Regulatory Compliance Assessment Report

Mixed Use Development, 810 Pacific
Highway, Gordon NSW

Date: 25/05/2026

Revision: 04

DRAWING TITLE:
Basement 1

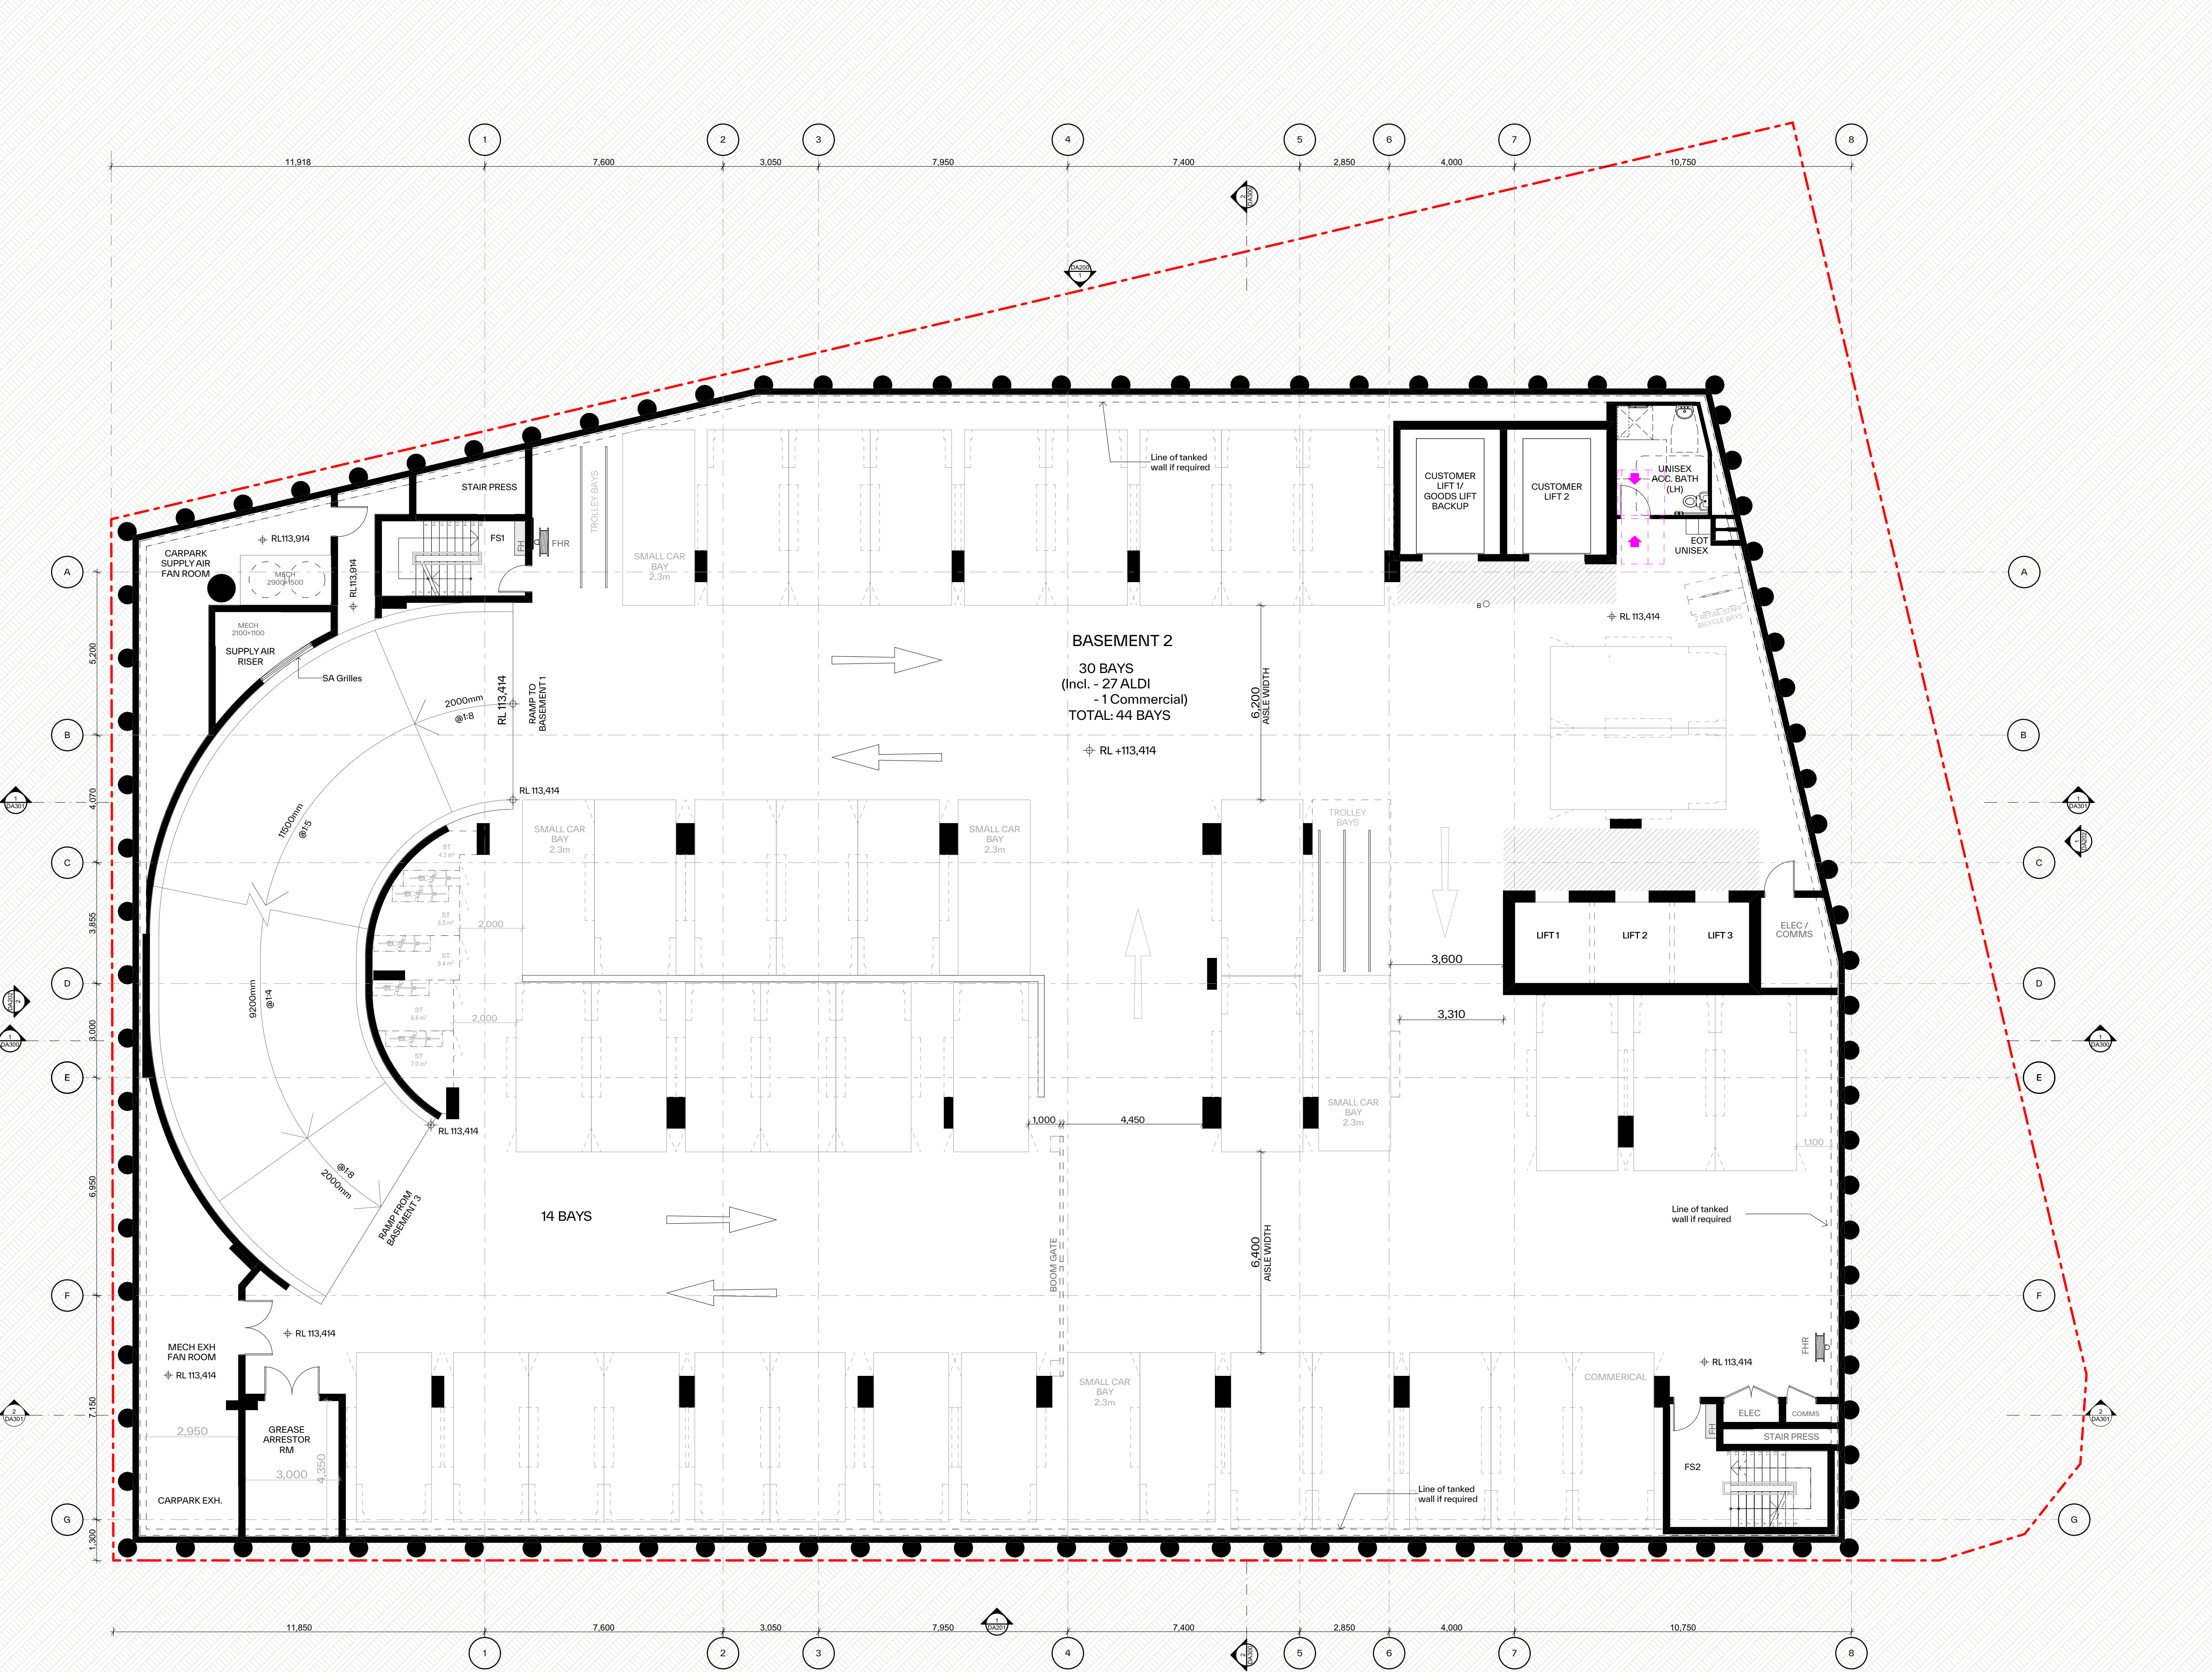
Level 25 appears to have a travel distance of ~9m in lieu of the prescribed 6m in lieu of the prescribed 6m.		
9	Fire hydrant coverage to Basement 1 appears to be inconsistent with AS 2419.1 coverage requirements of 40m to all areas.	E1D2	E1P3
10	The fire hydrant booster assembly does not appear to be visible from the same façade as the main building entrance.	E1D2	E1P3
11	Fire hose reels are illustrated further than 4m from a storey exit on the Loading Dock storey.	E1D3	E1P1
12	Internal fire hydrant illustrated further than 4m from a storey exit on the Loading Dock storey.	E1D2	E1P3
13	The fire control room does not appear to have a door from the front entrance and another direct from a public place or a fire isolated passageway connected to a public place.	E1D15	E1P6
14	Solar panel installation and Electric Vehicle provisions are typically deemed by Fire and Rescue NSW as requiring fire engineering assessment.	E2D17, E2D21	C1P2, C1P6, C1P8
